**WEST SUSSEX COUNTY COUNCIL
STRATEGIC PLANNING CONSULTATION**

DATE: 14 August 2015

SUBJECT: Application for approval of matters reserved by condition imposed under A/167/14/PL relating to conditions 3, 4, 6, 10, 11, 12, 13, 14, 15, 18, 20, 21, 22 & 23 for schedule of materials, tree protection, prevention of surface water drainage on highway, construction of roads, footways/casual parking areas, Travel Plan, archaeological programme, ecological mitigation report, broadband speed, foul water sewerage disposal, surface water drainage, SUDs system, refuse & recycling bins & decentralised & renewable or low carbon energy source.

Former Pound Nursery, Roundstone Lane, Angmering, BN16 4AL

TITLE
Section 278 Agreement Plan

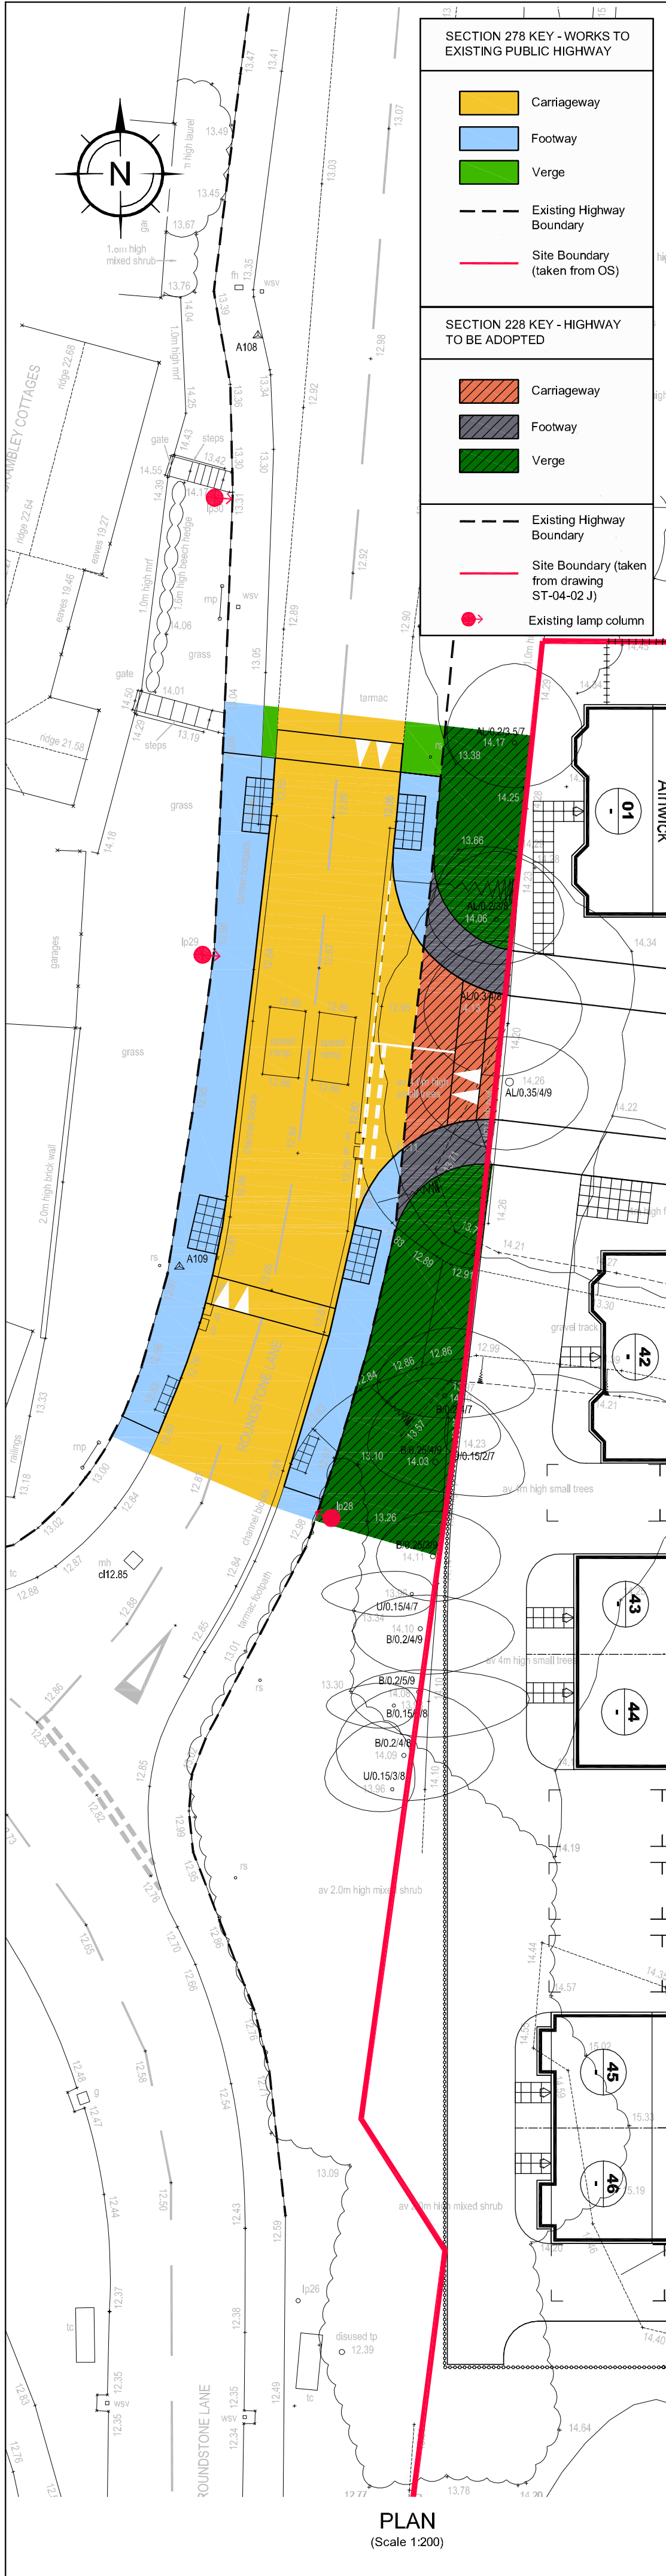
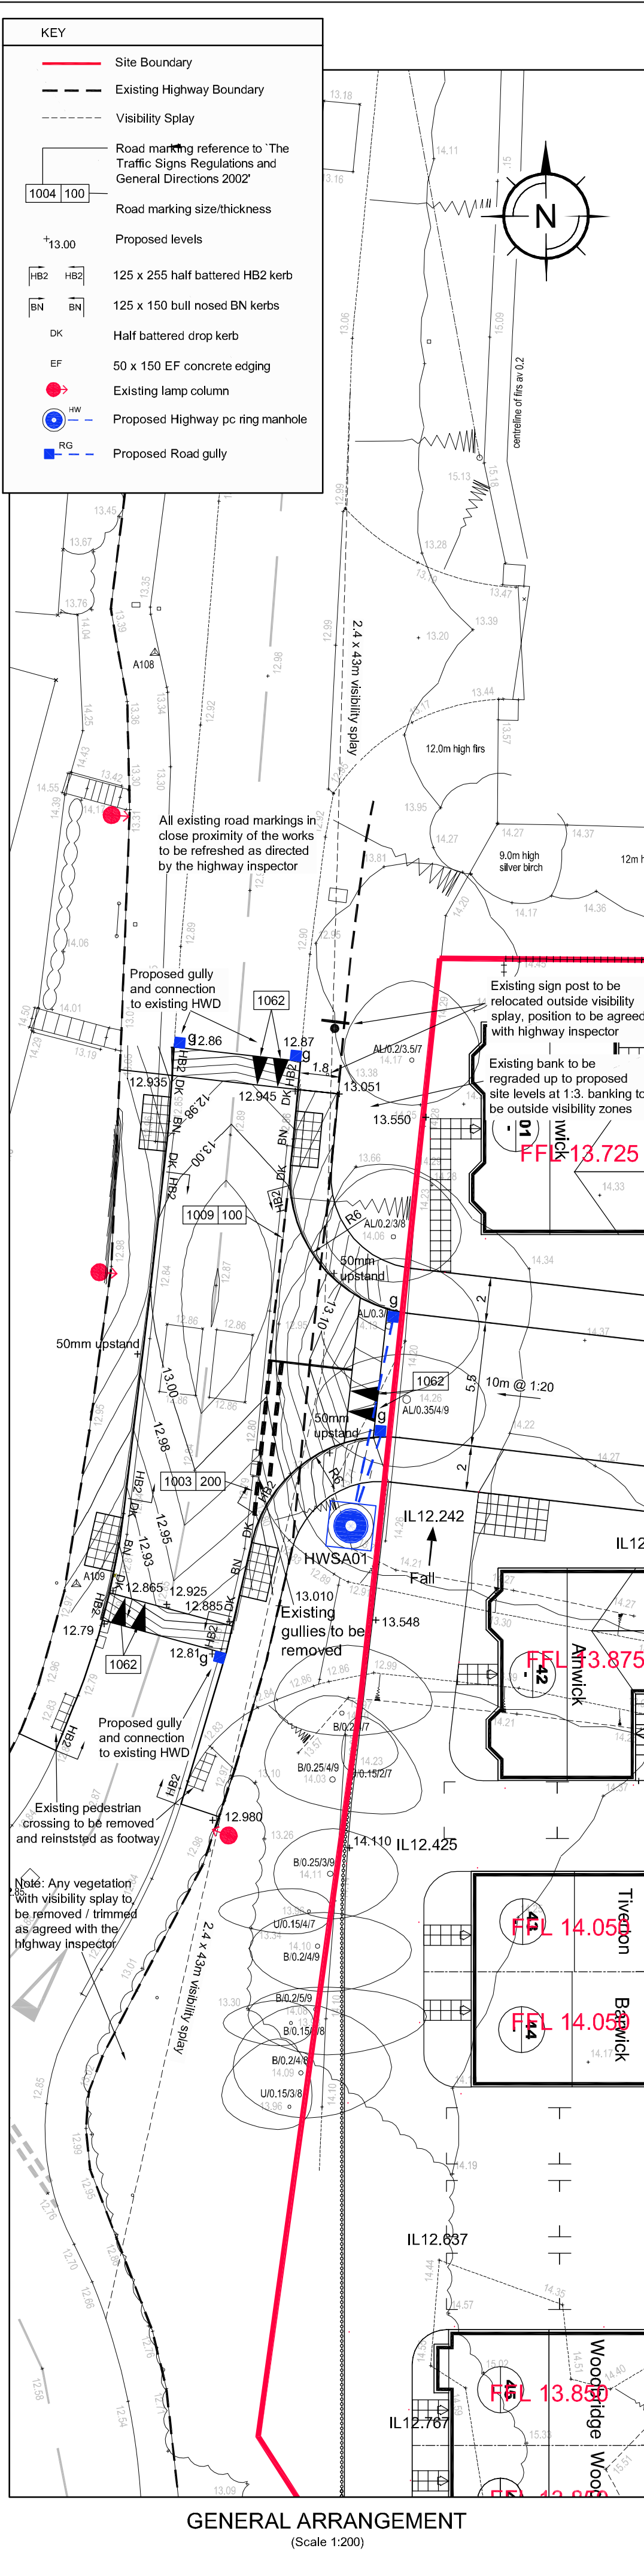
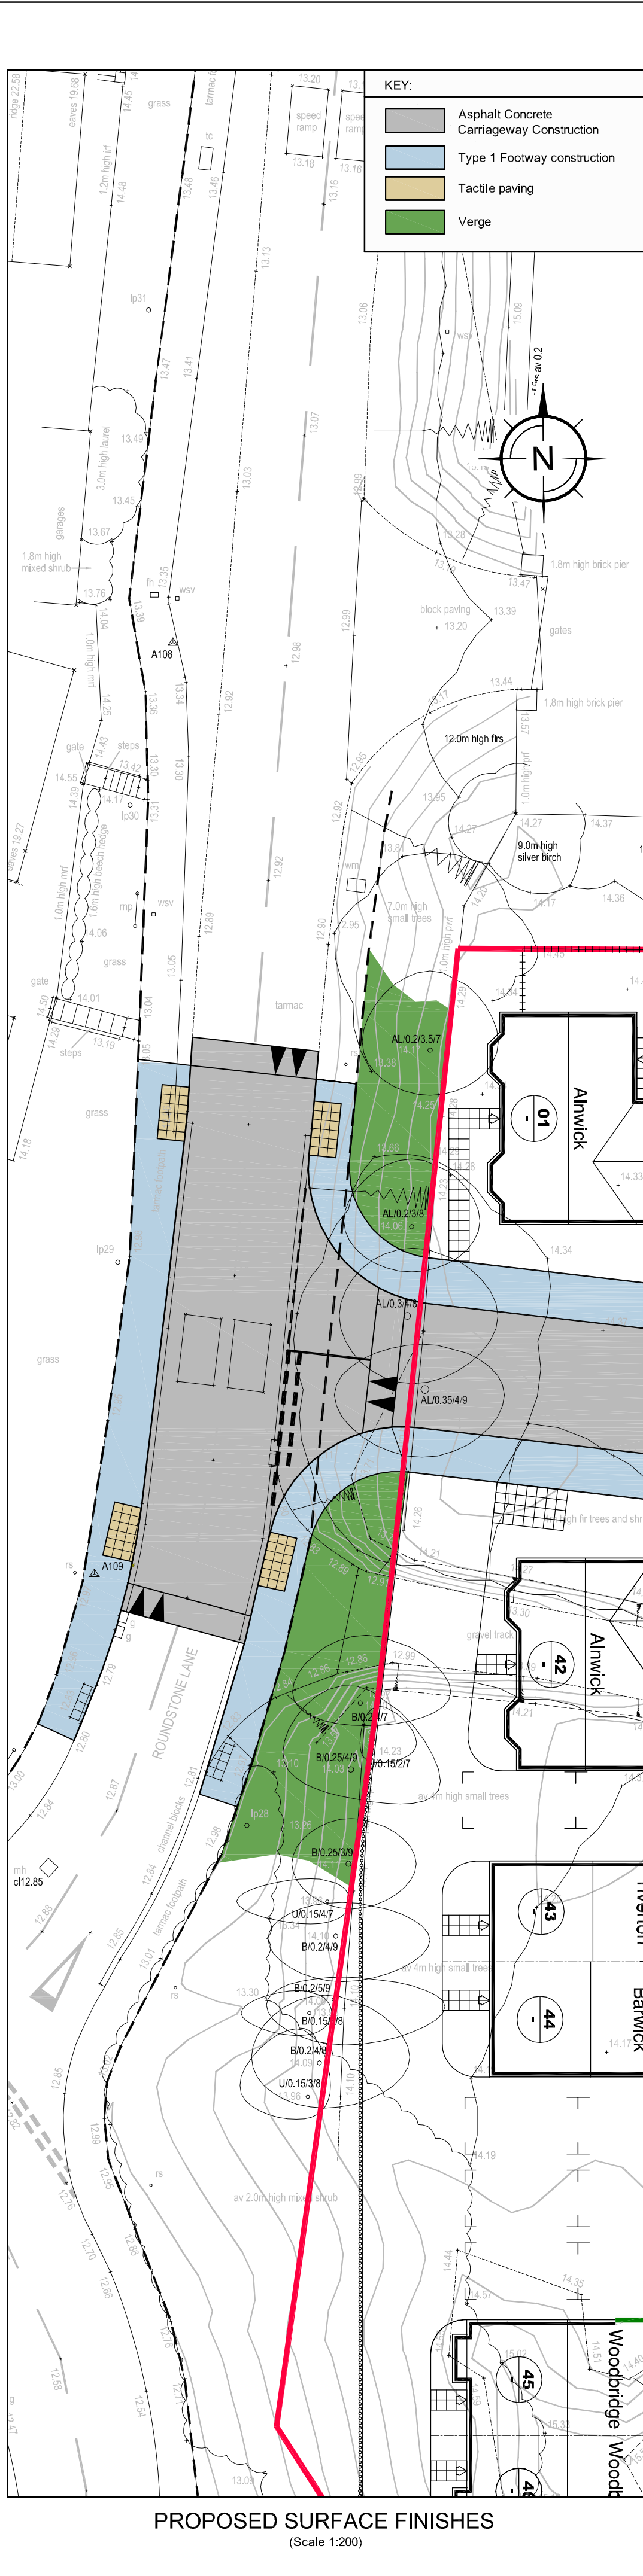
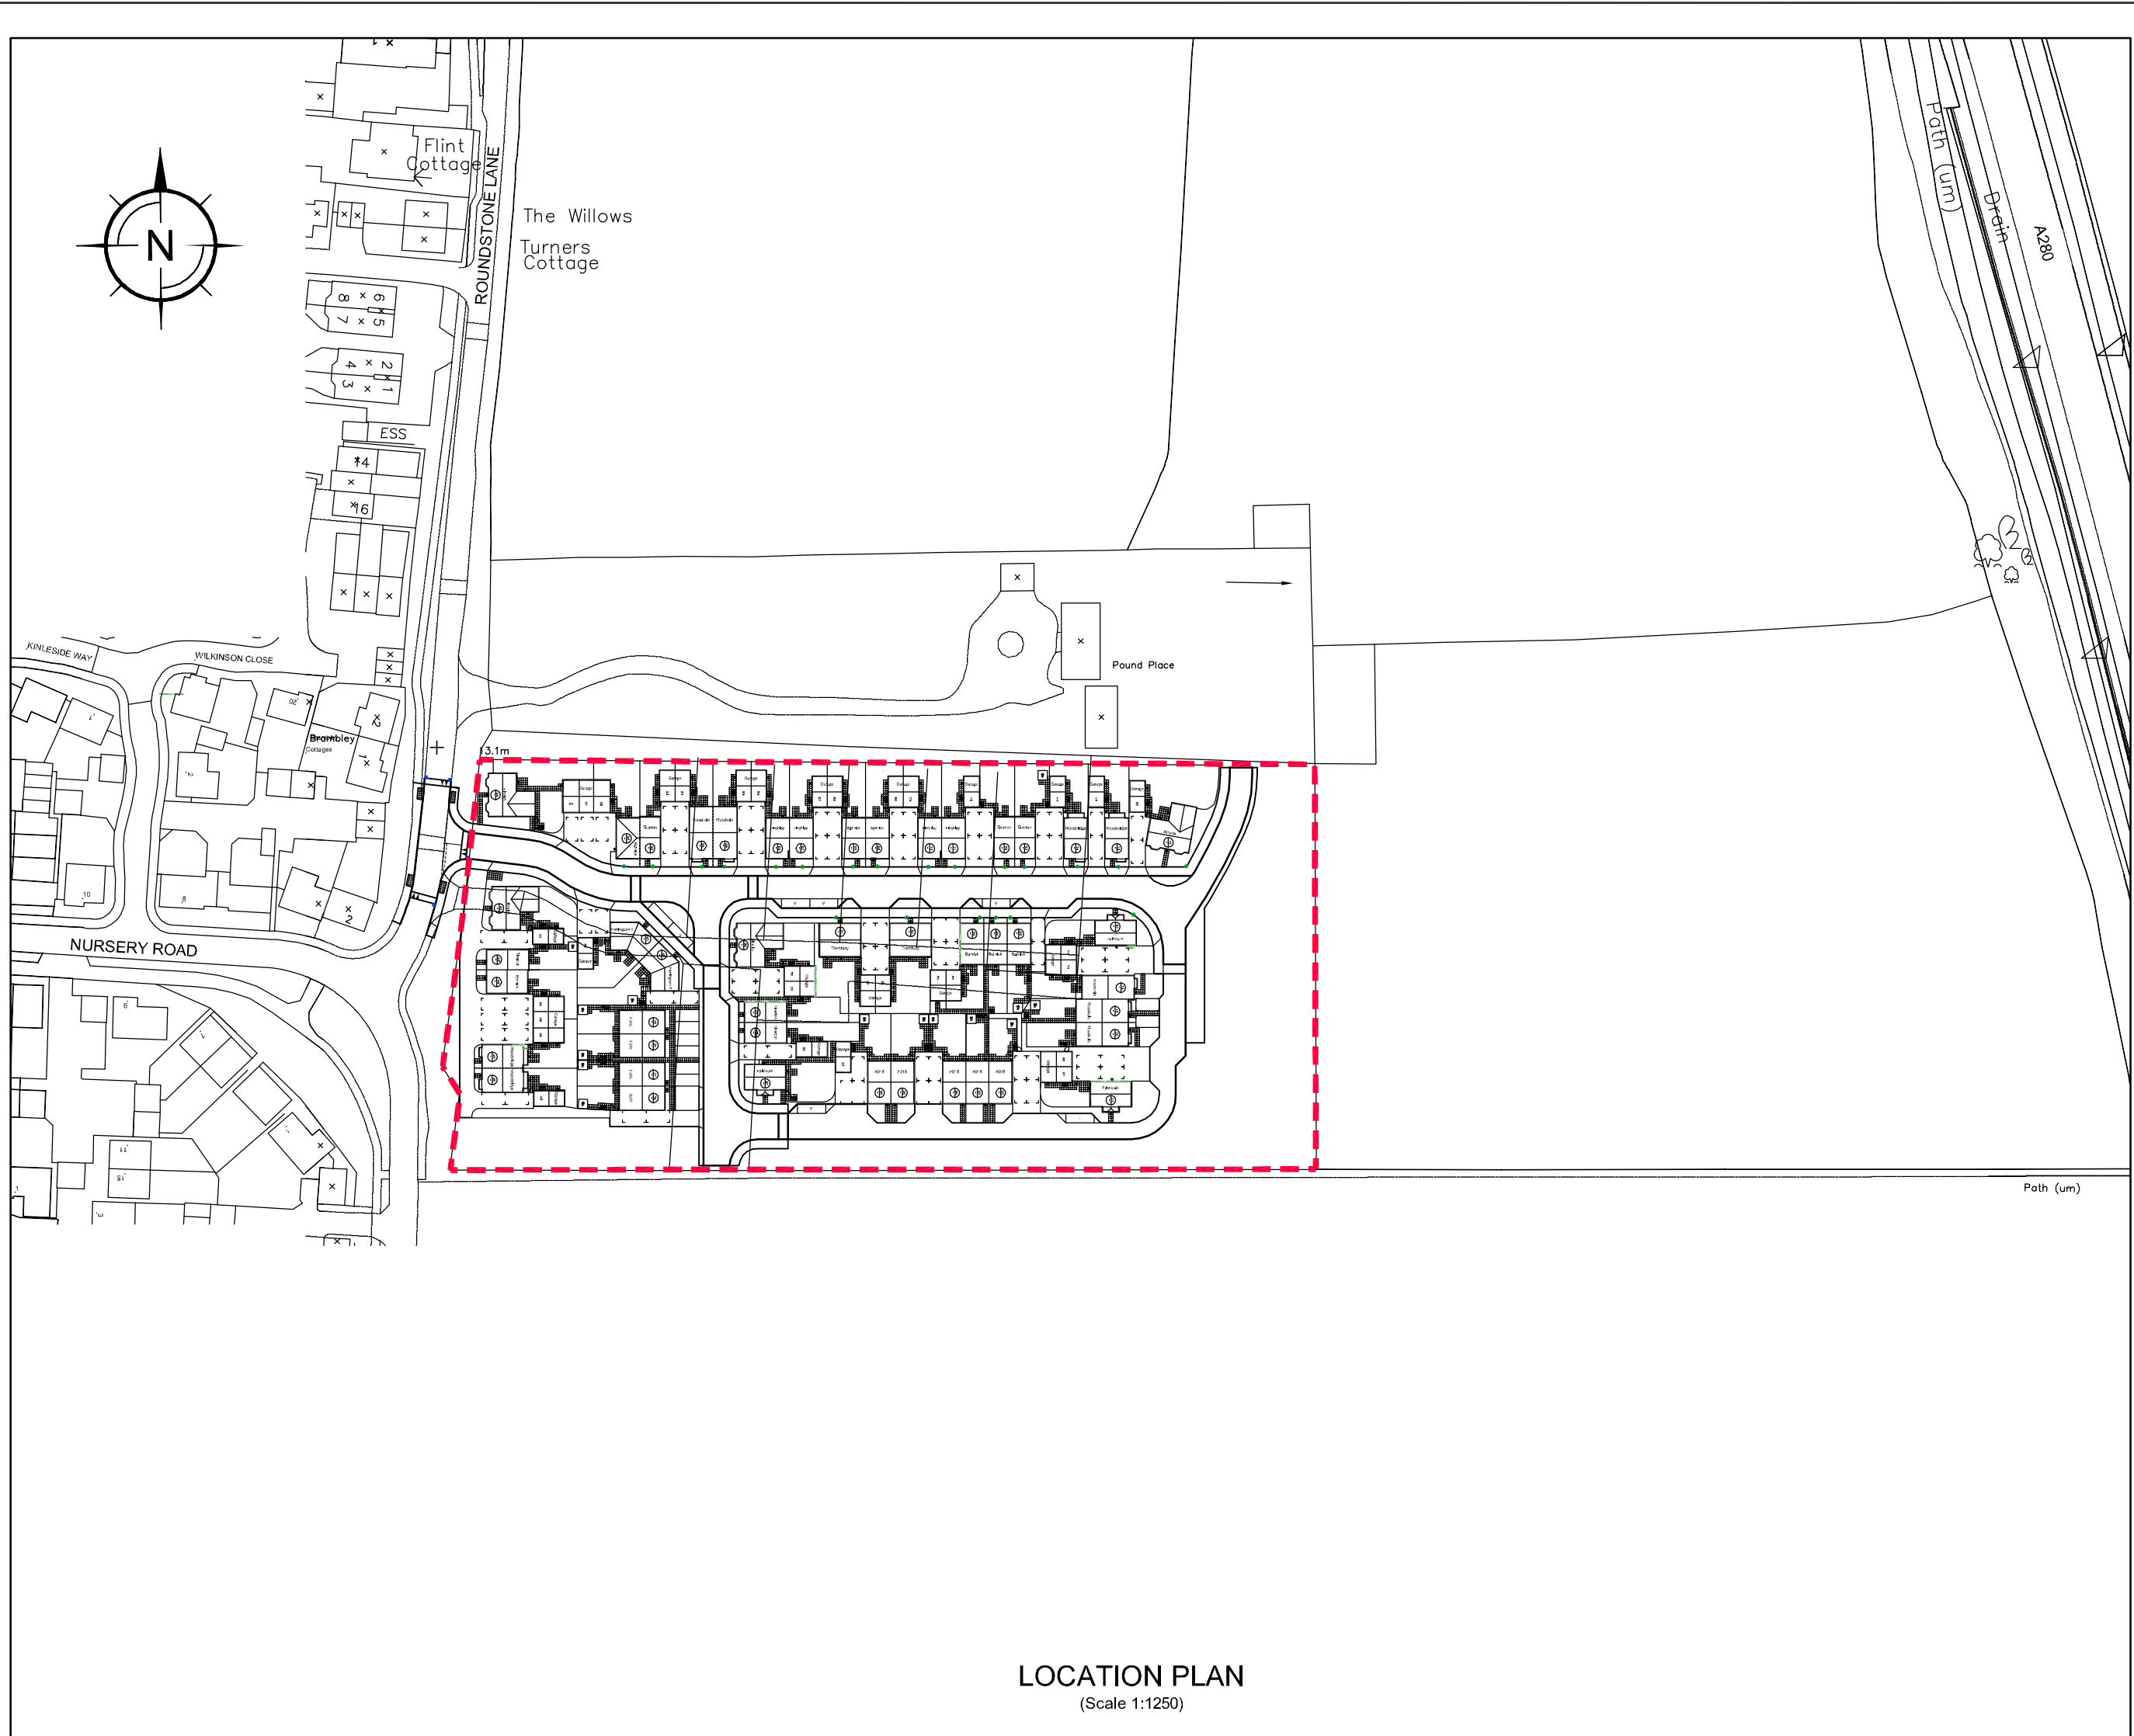
The proposed S278 & S38 works have now received technical approval, but the legal agreement is not yet in place. The works should be constructed in accordance with the agreed plans.
